Planning Application Ref: AB/107/17/T

Location : rear of 20 to 50 Fitzalan Road, Arundel

Description of works: Reduce crowns of trees generally by 1.5m overall except for trees 18 & 19 which need 2m reduction and also different treatment to one Ash tree

18, Willow trees x 1 Ash to the rear of
Properties No. 22 to 50 - Fitzalan Rd
Arundel.

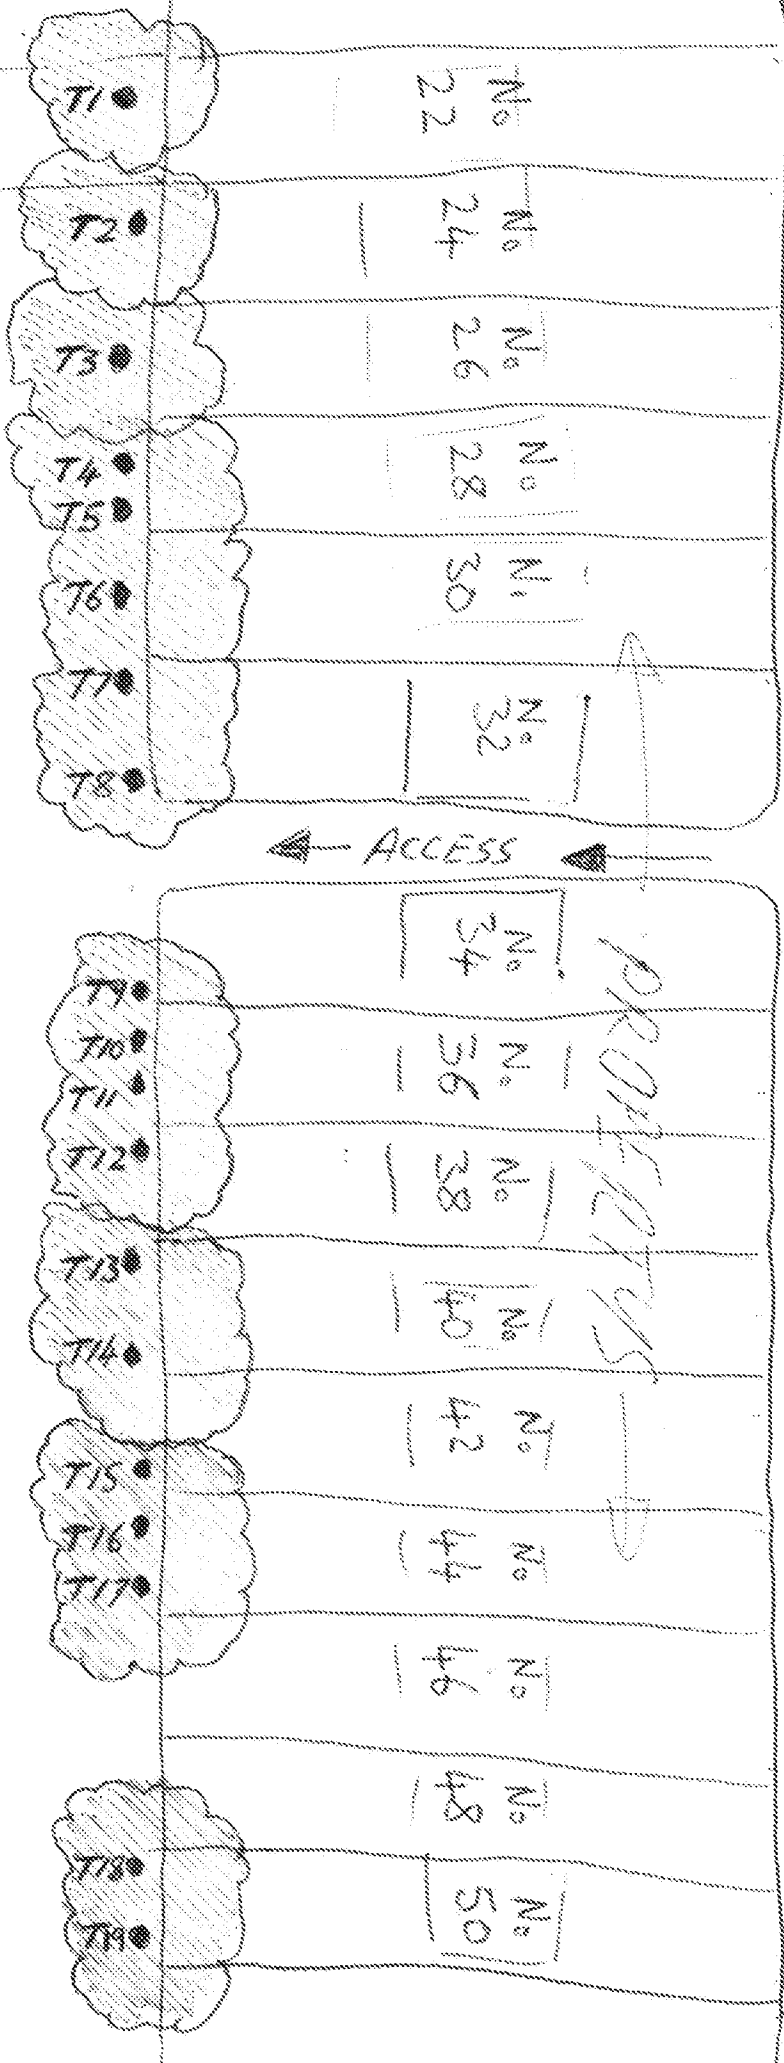
- These are medium sized tree located on the river banks abutting the rear gardens of the dwellings with low weeping habit over the gardens.
- Have been topped out in the past and are generally in good overall condition and make a significant impact in the landscape.

- The tree surgeons report is sound and well reasoned and makes sensible recommendations for the management of these trees.
- My only concern would be that the trees need some live branches left on them and must not be pollarded and left devoid of foliage altogether - so I would encourage the tree surgeon to bear this in mind.

- I raise **NO OBJECTION** to the reduction in lateral spread by 1.5m provided that it is done in a balanced manner and all other works listed in the tree surgeons report are acceptable as well.

- Where branches are to be shortened back the final cuts are to be made at the correct angle shown in BS3998:2010 and adjacent to a live bud or lateral **and MUST NOT exceed 75mm diameter.**
